Brad Saucier - Fwd: 11 Wakely Court, Portland ME

From: Jeanie Bourke
To: Brad Saucier; Lannie Dobson
Date: 3/6/2014 9:40 AM
Subject: Fwd: 11 Wakely Court, Portland ME
CC: Brian Laflamme; George Froehlich; Jonathan Rioux; Tammy Munson
Attachments: Fast Track Form.pdf; Electronic Signature Form.pdf; Building Permit Application.pdf; Railing Details.pdf; 1st Floor Layout.pdf; 2nd Floor Layout.pdf

**2nd Floor**  
**11 Wakely Ct, Portland**

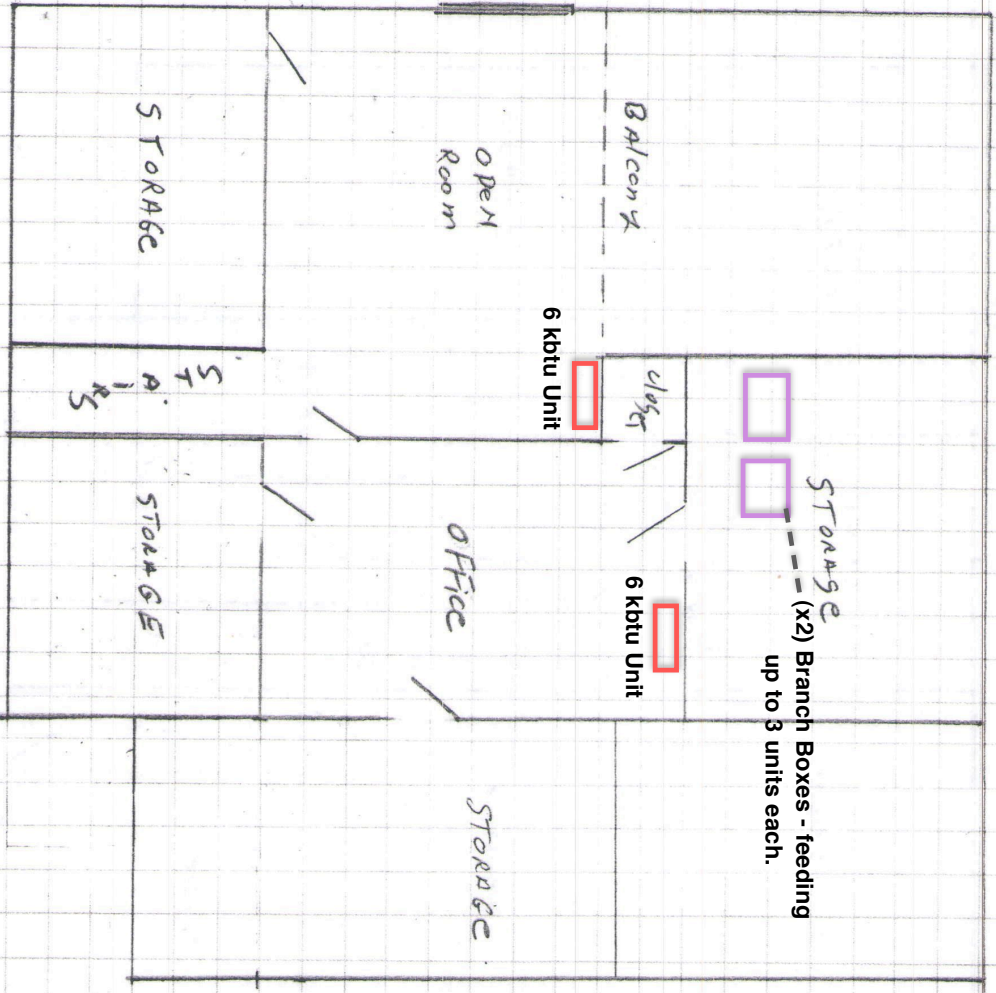
There are some issues with it, I spoke with the contractor and he will be modifying the proposed work. I have not approved finishing of the storage room above the garage, it shall remain a storage area until the condo association approves the addition of an egress window.
